RE: SP-25-00007 Suncadia Ph3 Div 18

TO: All Staff
FROM: Public Works Plan Review Team
DATE: July 16, 2025
SUBJECT: SP-25-00007 Suncadia Ph 3 Div 18

SUNCADIA P3D18B1

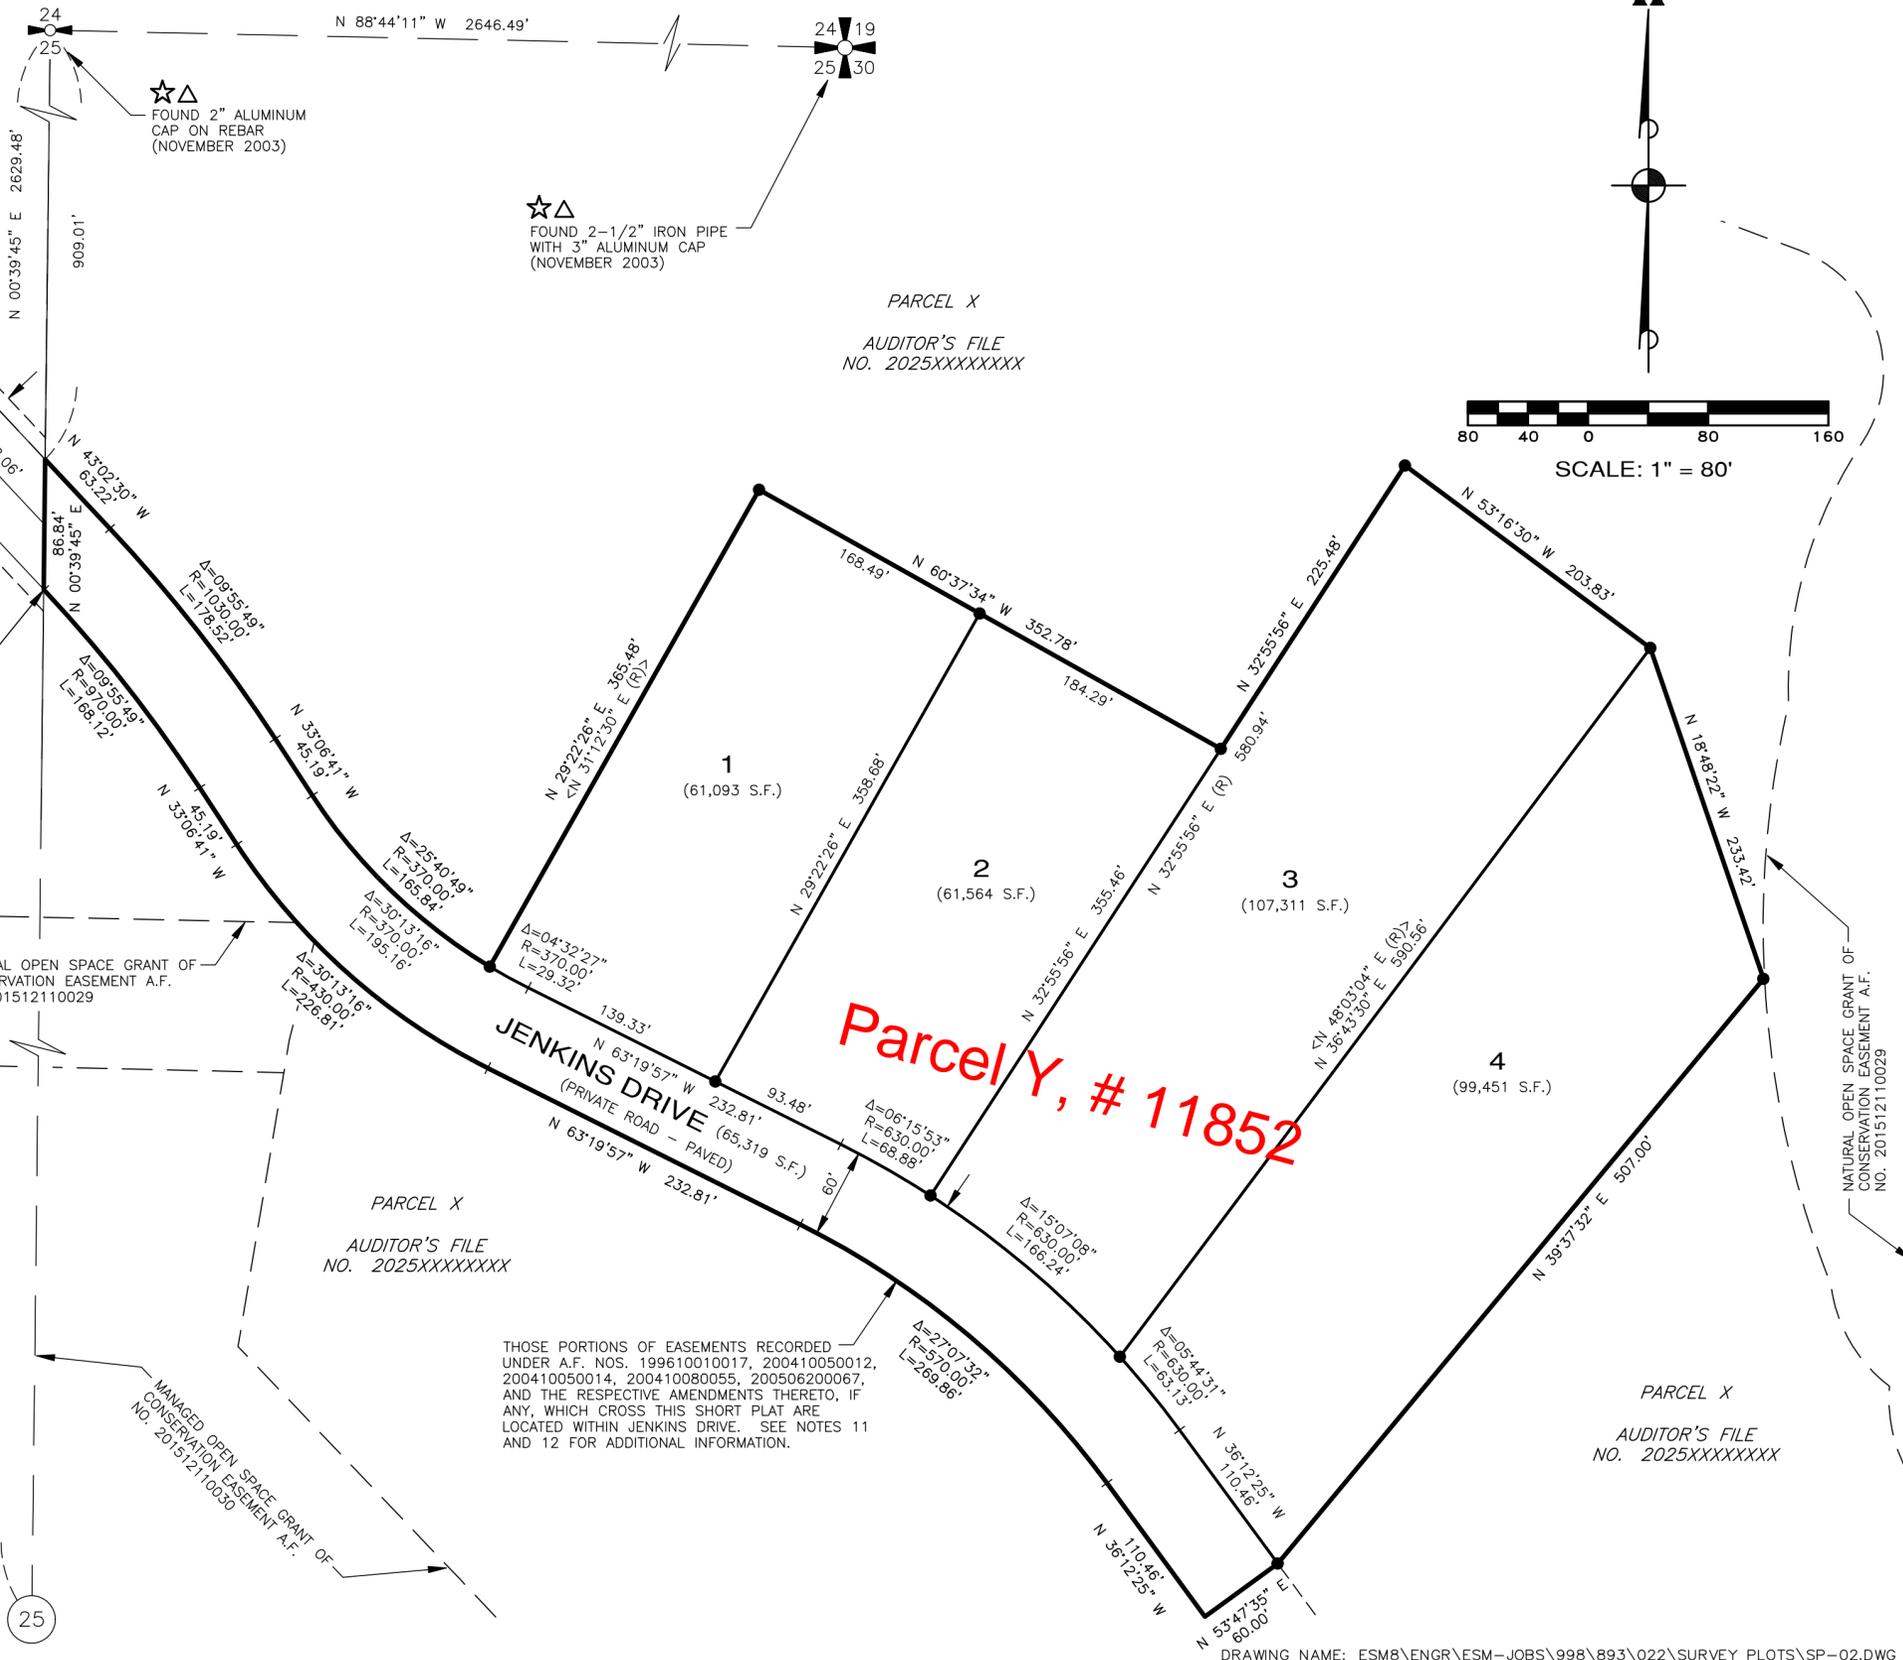
SURVEY	<p>NOTE: All survey comments are based upon the assumption that the previous record of survey (Application; BL-25-00006) will be filed PRIOR to preliminary approval of this Short Plat application.</p> <ol style="list-style-type: none"> 1. Add set corner symbol to the legend, together with a description of what was set. 2. Please include Name and Address of Engineer of Record as well as the Date of the Survey (per KCC:16.12.020(5)) 3. Please provide an updated Subdivision Guarantee containing legal description that matches the legal description on the face of the Short Plat. (subject to recording of (BL-25-00006)). 4. Existing Contours are to be shown, and sufficient data included to meet the requirements of WAC:332-130-145. 5. Please Show "Short Plat" at the top of the page, together with a unique name for the subdivision. (JT)
